Please upload the email and the attachment from **Angmering Parish Council** objecting to reserved matters application **A/179/20/RES**.

South of Water Lane Development, Angmering - A/109/20/RES

The Illustrative Visuals (Oct 2020) of the Views from Water Lane show that the proposed landscape screening of the development is to be achieved by planting trees in the Black Ditch floodplain.

Figure 8.4: Scenario 3: Flood risk to the Land South of Water Lane development for a fully implemented FAS, from a 1% AEP + 45% CC event.

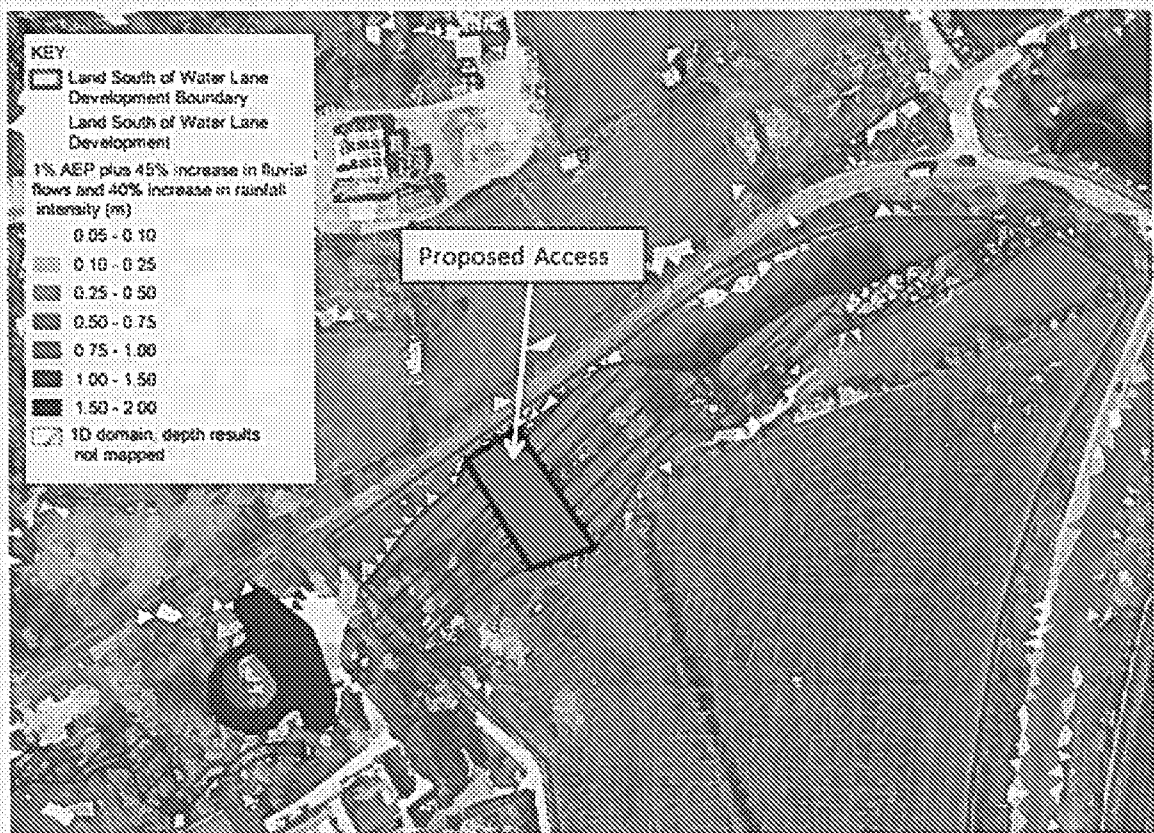
Part of the EA Angmering FAS, states that the bridge has been designed to hold back flood water behind an embankment, and will increase the depth of the usual winter flood levels shown left.

Planted on ground that will typically remain soft and wet, how vulnerable will they be to being uprooted during periods of heavy rain and gales?

APC are also concerned about the problems of debris such as branches, twigs and leaves washing downstream and blocking the culvert entrance. Will this require additional screening and monitoring having to be built into the design of the culverted embankment?
